From: [Chris Hasz](#)
To: [Jamey Ayling](#)
Subject: Public Comments on CU-23-00003 Fowler Creek Guest Ranch
Date: Thursday, October 19, 2023 4:13:28 PM

I appreciate you taking the time to read through these responses. My name is Chris Hasz and I live at 741 FSR 4517, along the proposed property line for the **Fowler Creek Guest Ranch** Project. I have significant concerns about the Compliance, Safety, Impact, and Operations of this project as submitted. While the project contained numerous details on what features and facilities the developer intends to build, the proposal was incredibly vague on details of how they will ensure these facilities and proposed usages will be in compliance with Kittitas county and Washington state laws.

FOWLER CREEK GUEST RANCH
EXHIBIT 12
EMERGENCY INGRESS AND EGRESS PLAN

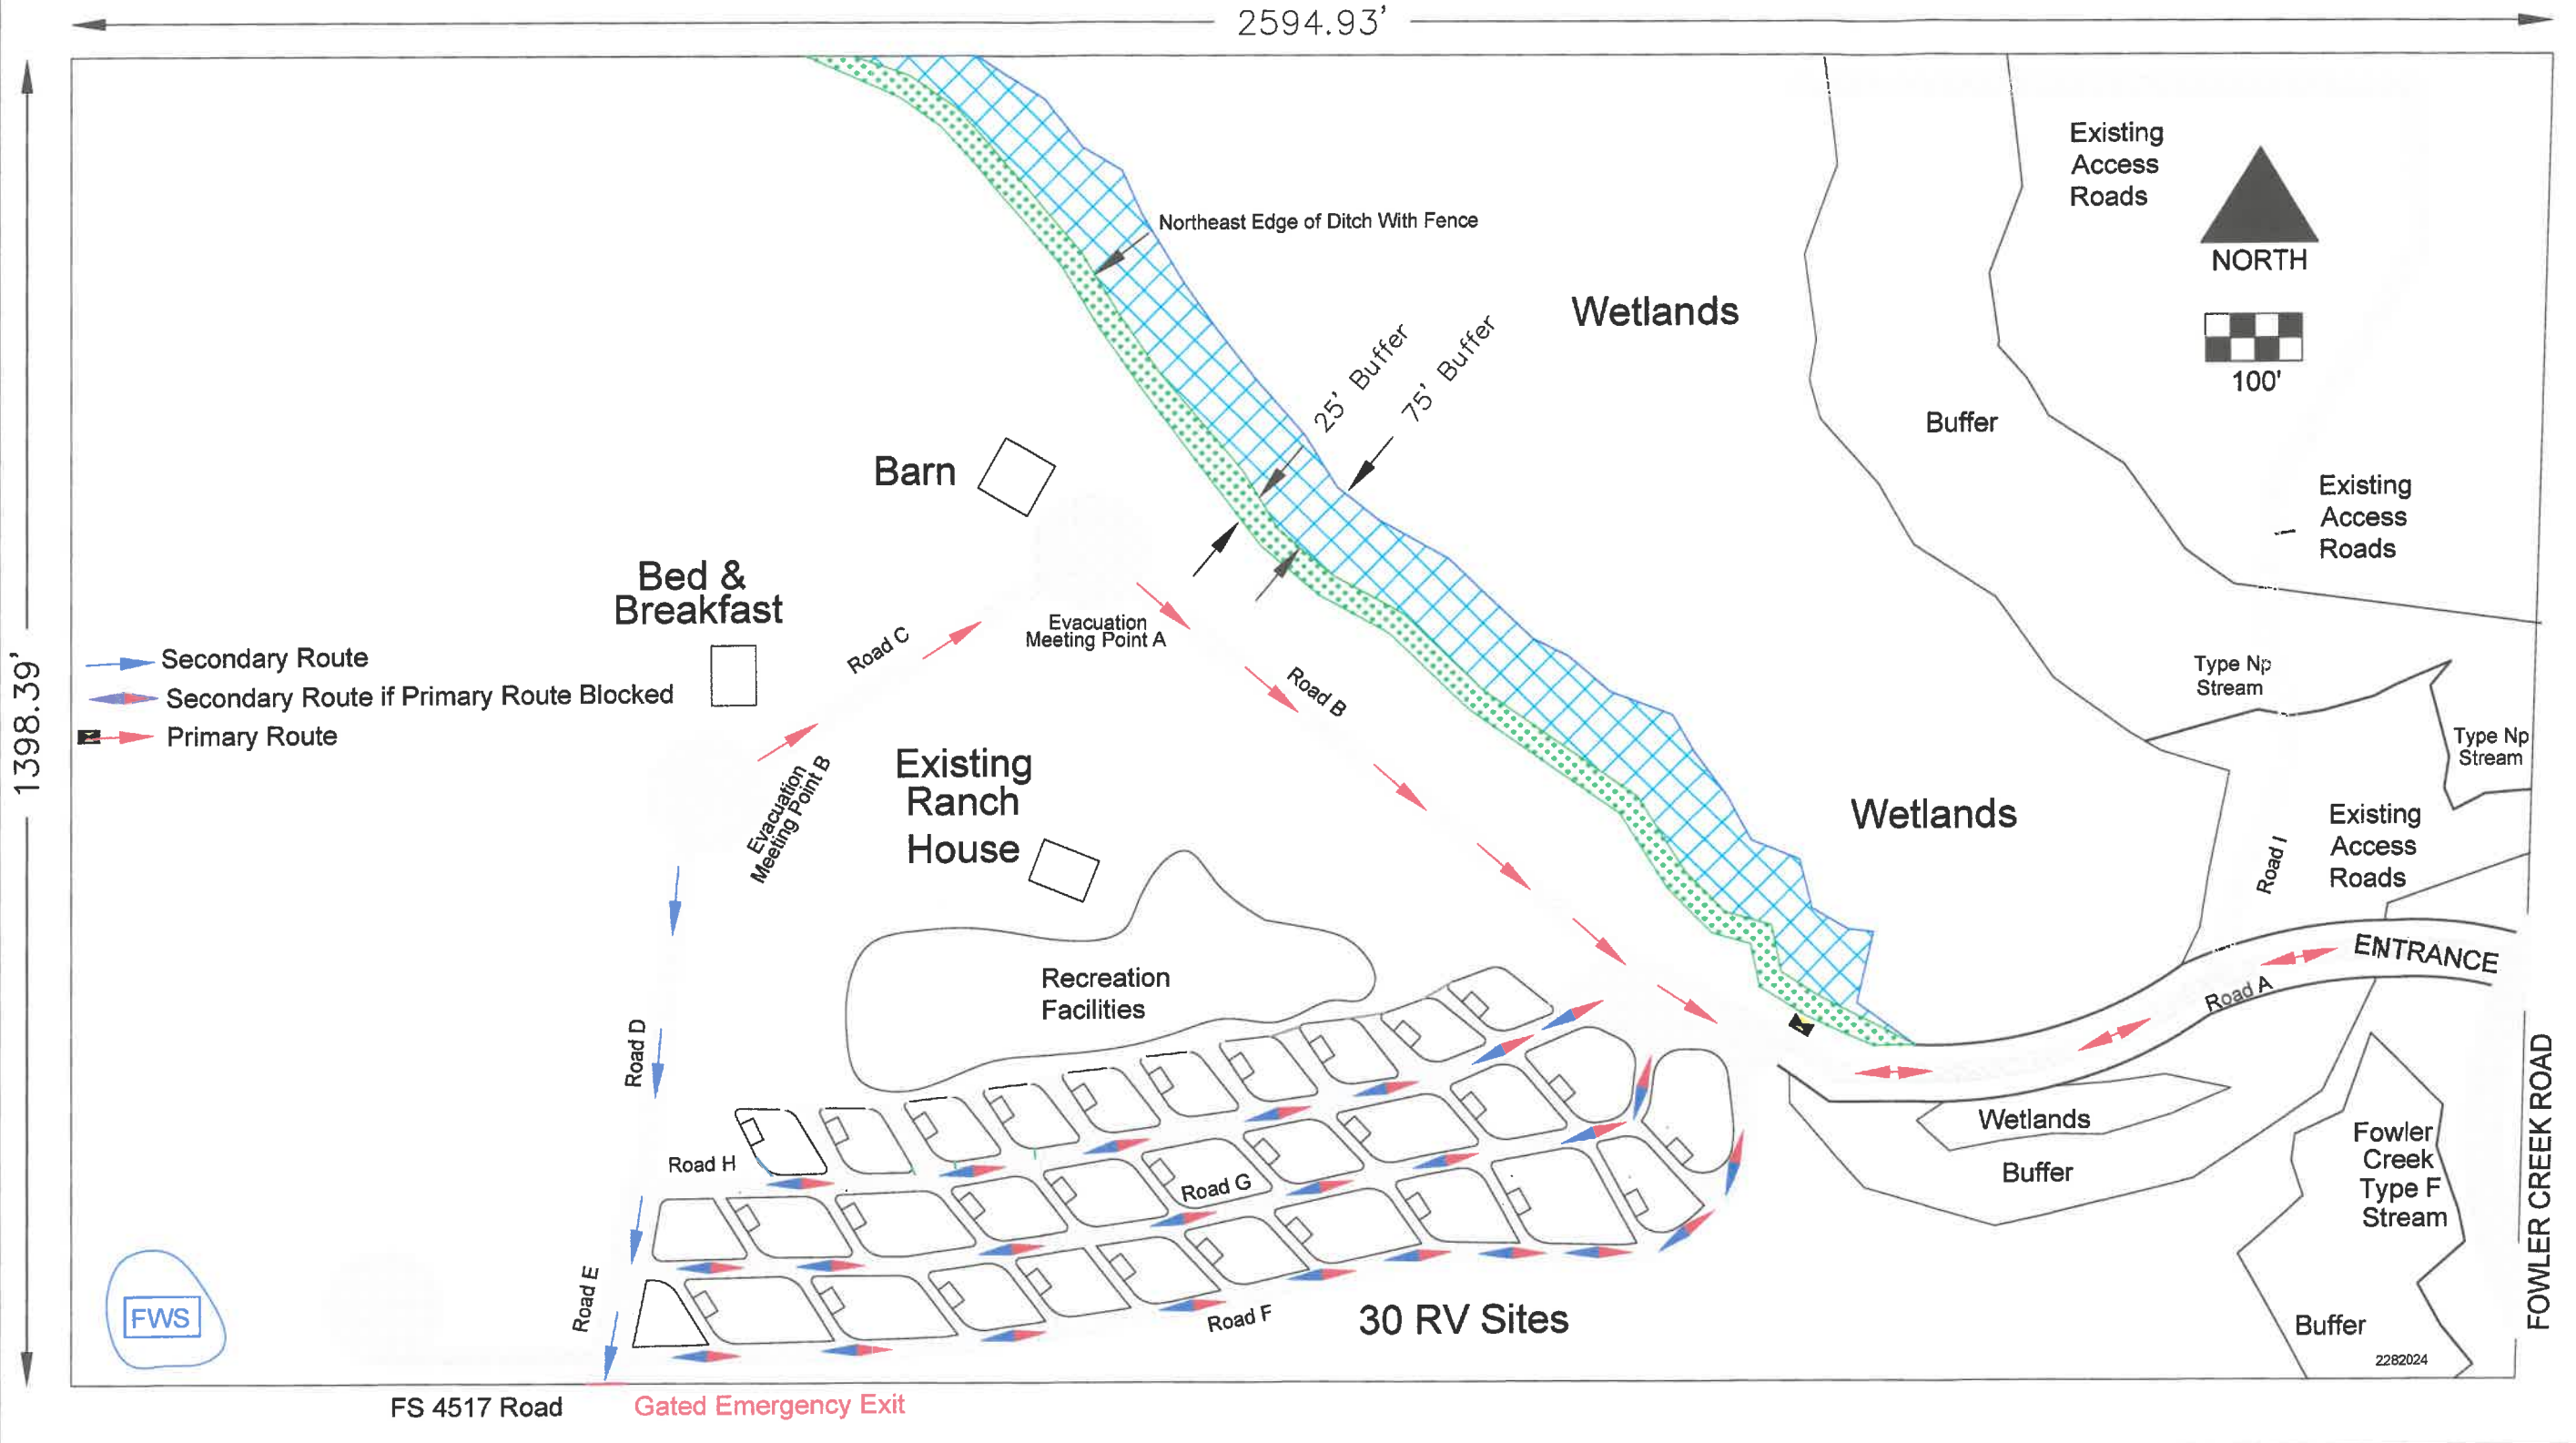
- ingress/egress. The proposed project identifies a small access road, on an easement through my property, as the primary exit for this project. Not only is there inadequate space granted to allow egress of large vehicle and trailer combinations, it will add (by the project's own minimum traffic listings) 100+ daily travel events out onto Forest Service Road 4517 which is inadequate (see above) to handle this level of traffic safely. In addition, users of this proposed

development will be using this access as ingress/egress for a large number of ORVs, adding additional concerns of noise, safety, and traffic. There is no way that Forest Service Road 4517 can support this traffic and alternate entrance/exit areas should be implemented.

EXHIBIT 16 - SITE PLAN - FOWLER CREEK GUEST RANCH

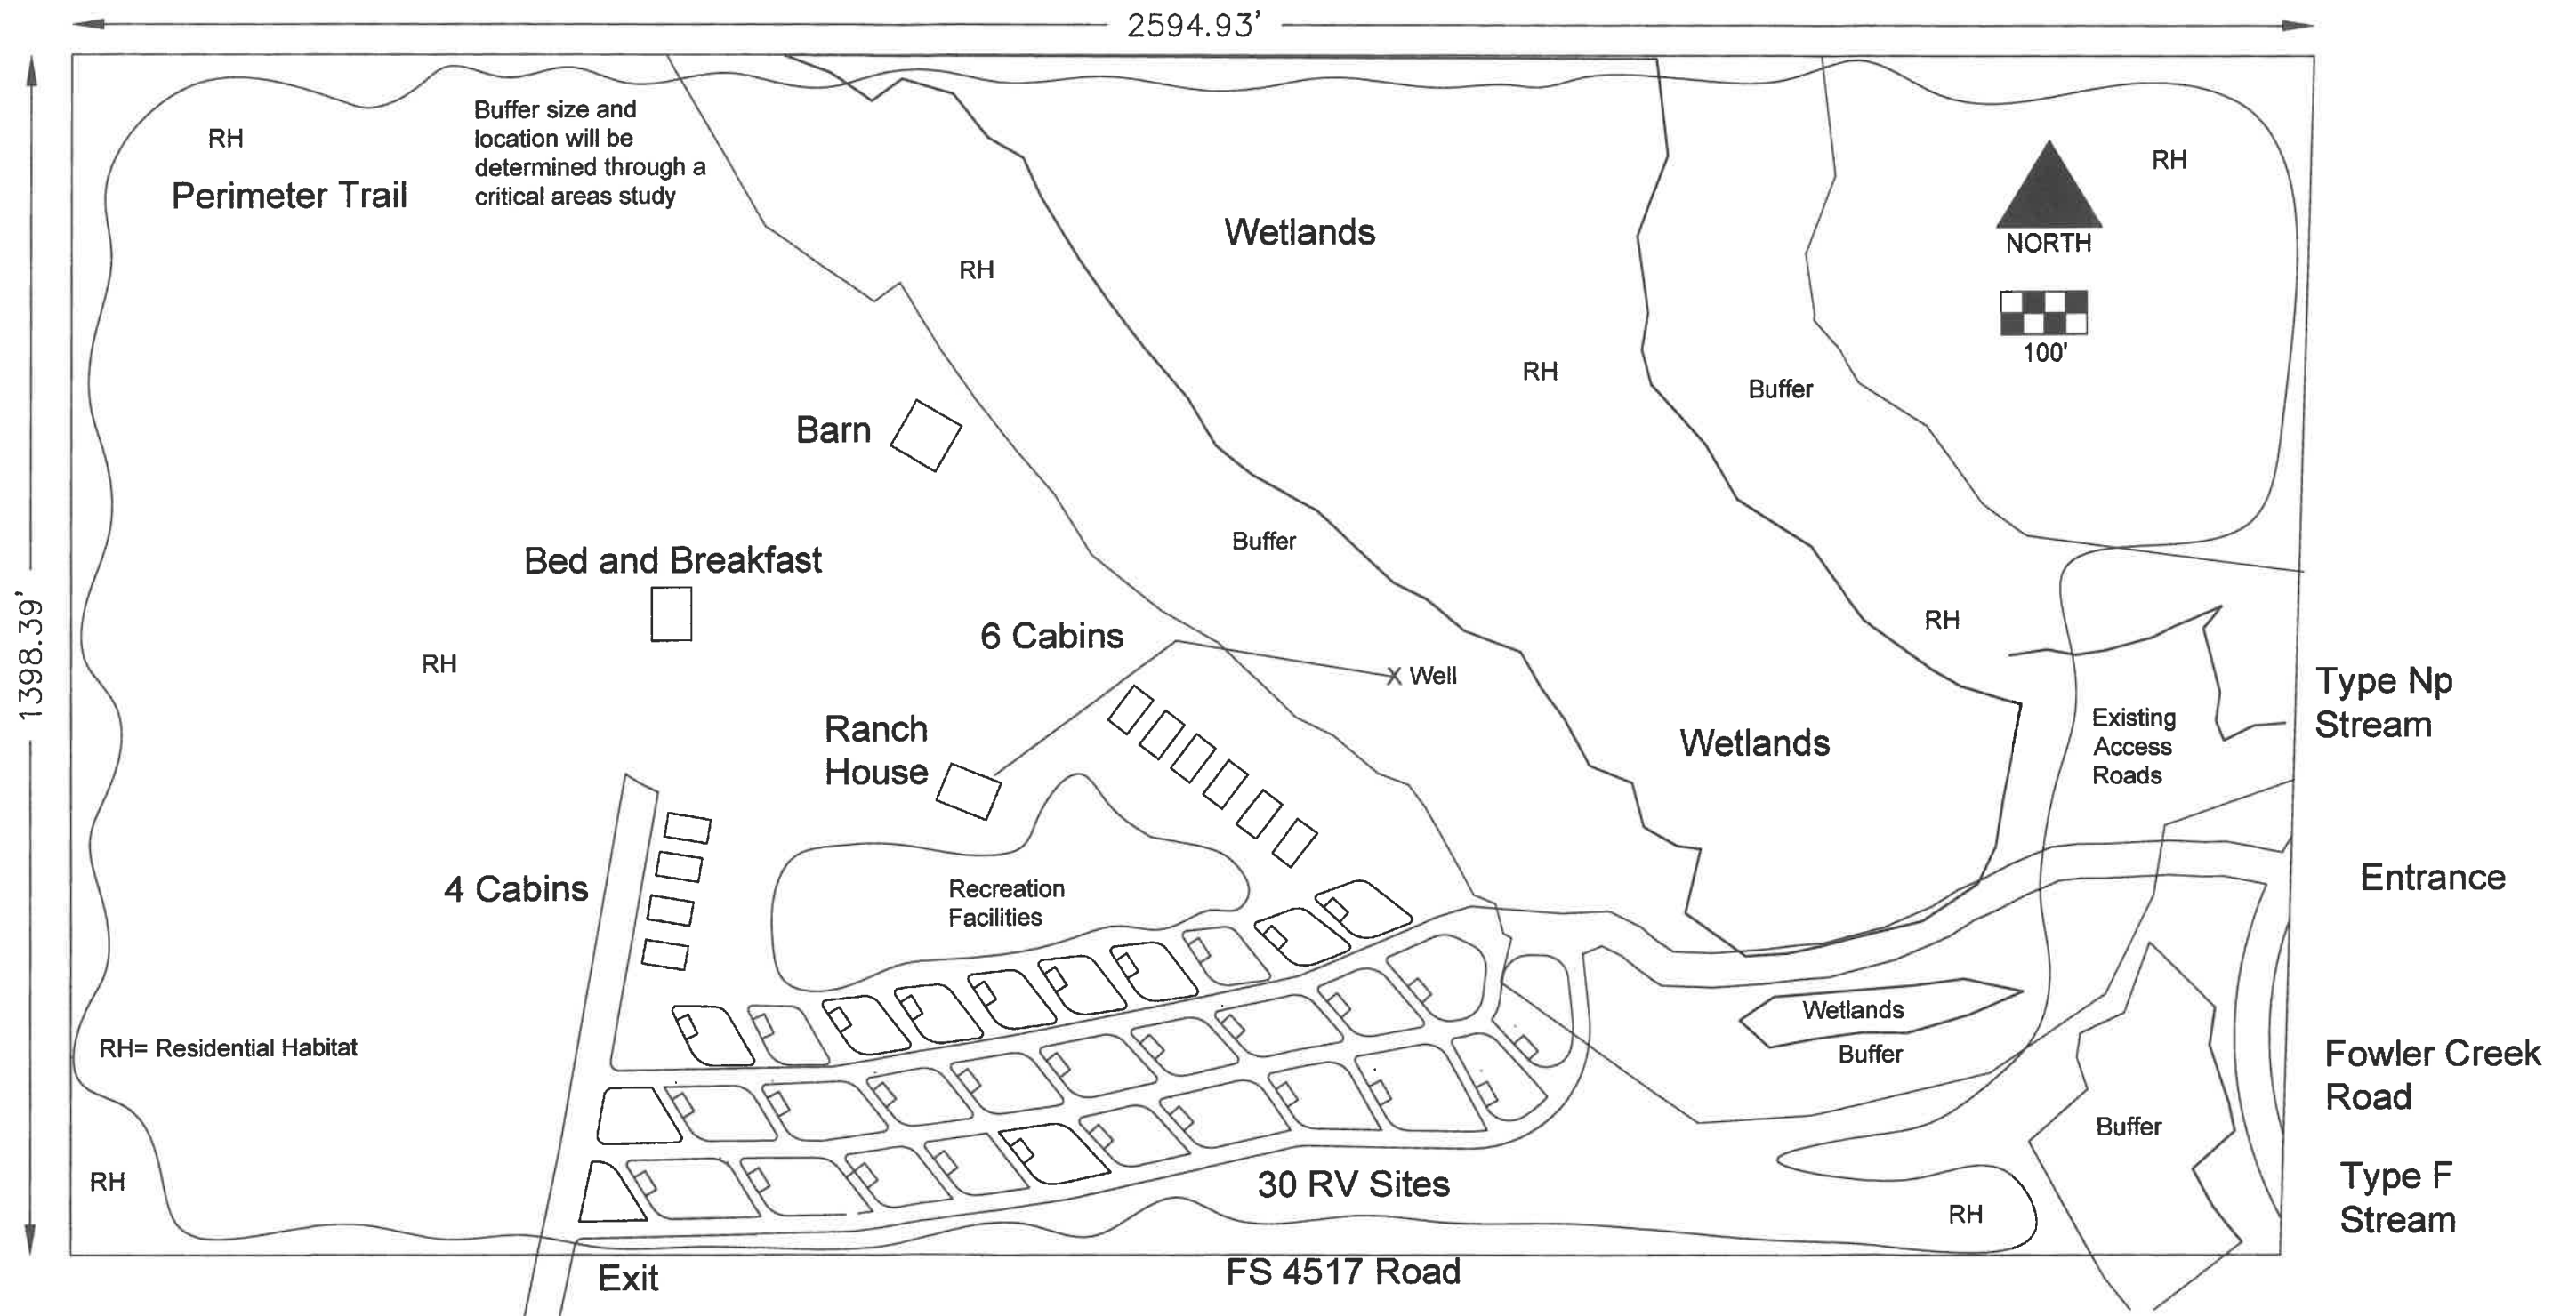
- As an adjacent landowner, I do not see any mitigating efforts in this proposal for identifying land boundaries. I am concerned that with the large number of amenities, including RV sites, along the southern edge of this development and northern edge of my property, that myself and other adjacent property owners will deal with a constant stream of people trespassing on our lands, causing a number of safety and liability concerns.

Additionally, the proposal identifies the stretch of property directly adjacent to my property which would be used for 30+ RVs. The constant noise from this configuration would be incredibly detrimental to the character of an R5 zoned property. I would have the developer provide a full noise mitigation plan, authored by a subject matter expert or remove the noise
